**POND 1 – HOMESTEAD AT STERLING RANCH FILING NO. 2
MAINTENANCE AGREEMENT
EXHIBIT “A”**

POND 1 - HOMESTEAD AT STERLING RANCH FILING NO. 2 MAINTENANCE AGREEMENT EXHIBIT "B"

POND 1 - HOMESTEAD AT STERLING RANCH FILING NO. 2 MAINTENANCE AGREEMENT EXHIBIT "B"

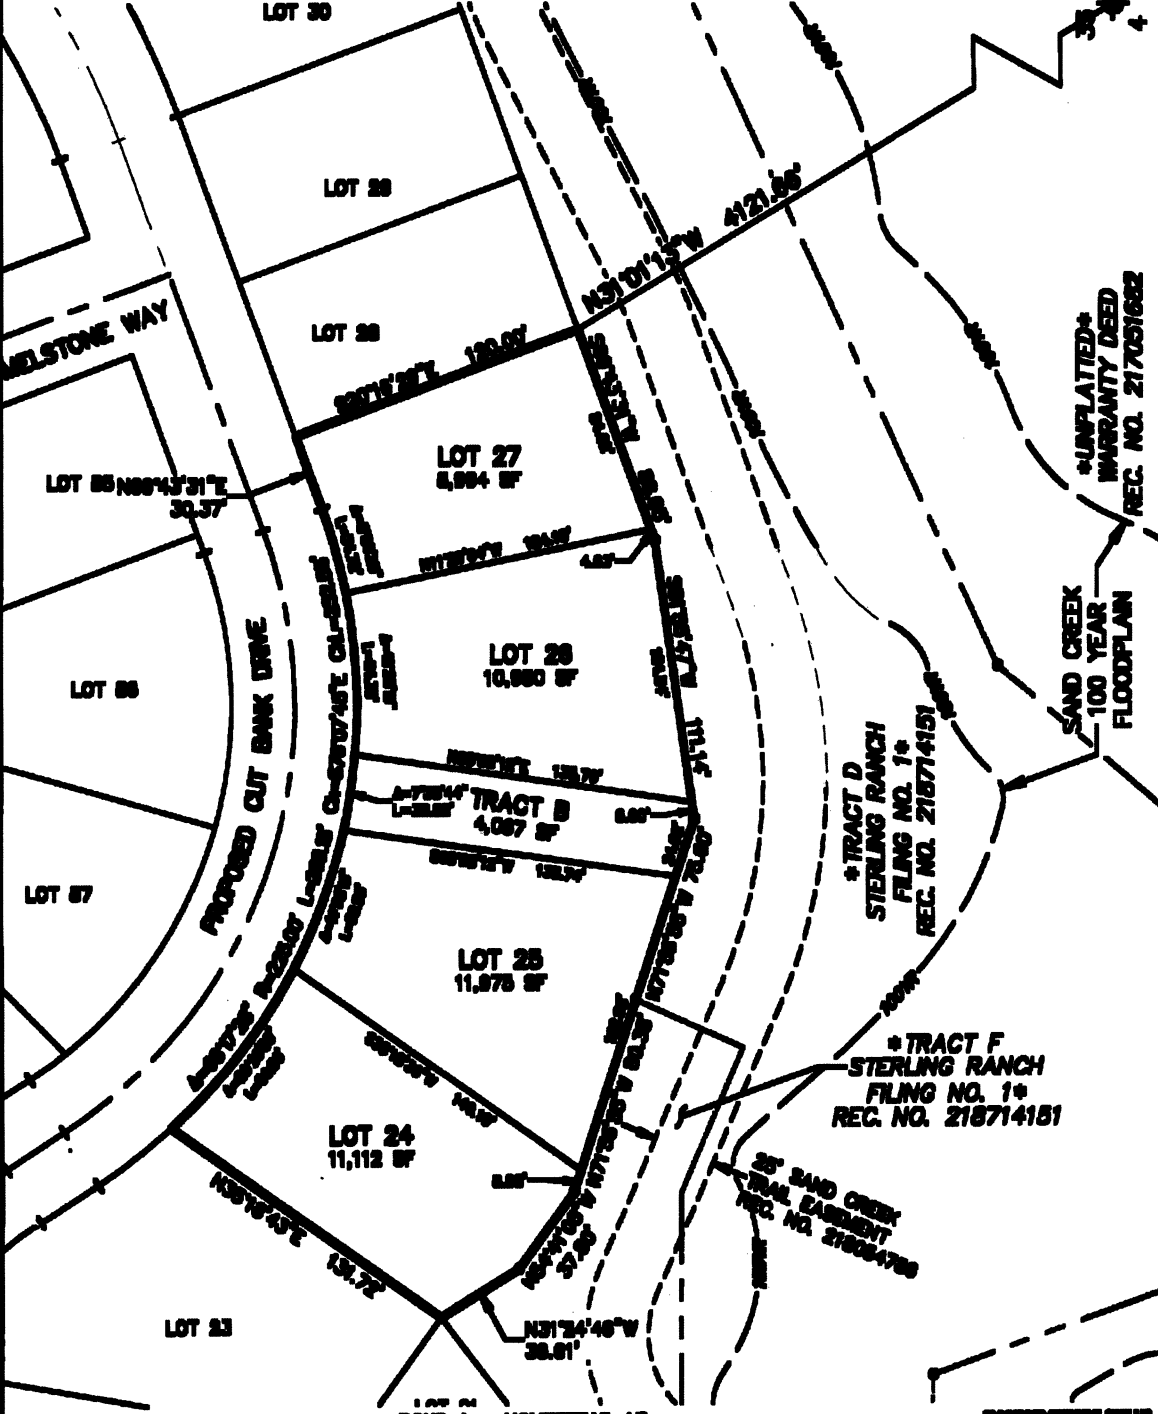
Add easement for SFBs.

Also need exhibits
for the sand filters.
